17/1/2023

**External Application –
External/2022/0010
Trinity Grammar School (SSD-10371-Mod-5)
119 Prospect Road and 50-52 Seaview Street, Summer Hill**

Figure 4 Extract from Demolition – Block 03 – Quadrangle Building L0 Floor Plan showing detailed breakdown of the proposed works to the Quadrangle building.

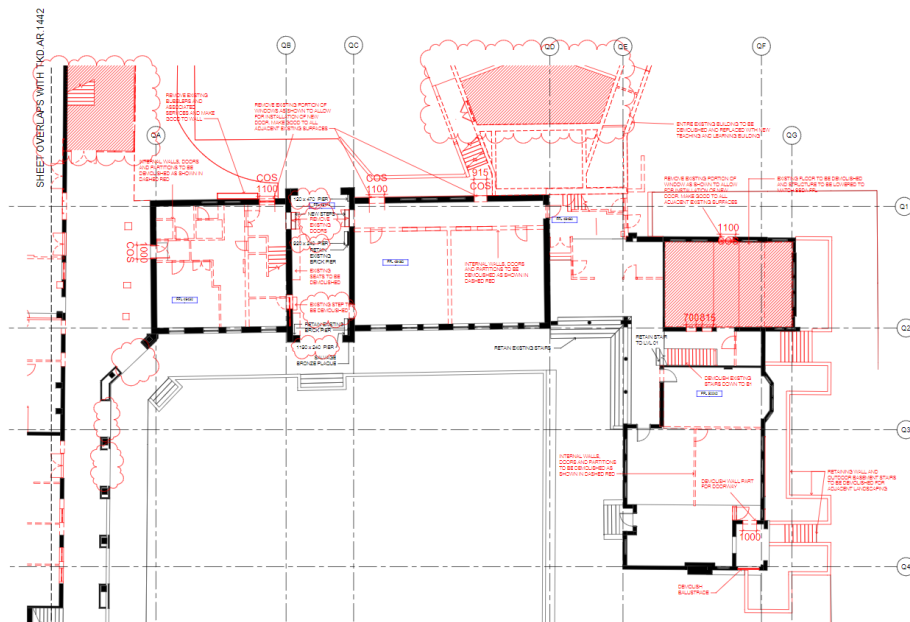
The assessment of heritage impact provided with this MOD does not provide any detail as to the existing materials or building configurations proposed to be altered. No images have been provided of the areas noted as having significant fabric proposed to be changed. The materials are not shown on the plans, with the architectural

drawings simply stating where an existing building is to be 'refurbished'. Unless the exact nature of the fabric that is proposed to be altered has been identified, the heritage impact cannot be fully assessed.

A more detailed assessment of heritage impact is required, that provides a higher level of information in regard to each proposed change to buildings and areas such as the quadrangle building identified as having heritage significance. Photographs of the areas proposed to be altered that are within buildings identified as being of heritage significance are to be provided. The materials of the fabric that is proposed to be altered is to be correctly identified, as is their age and integrity (ie original, early modification &c).
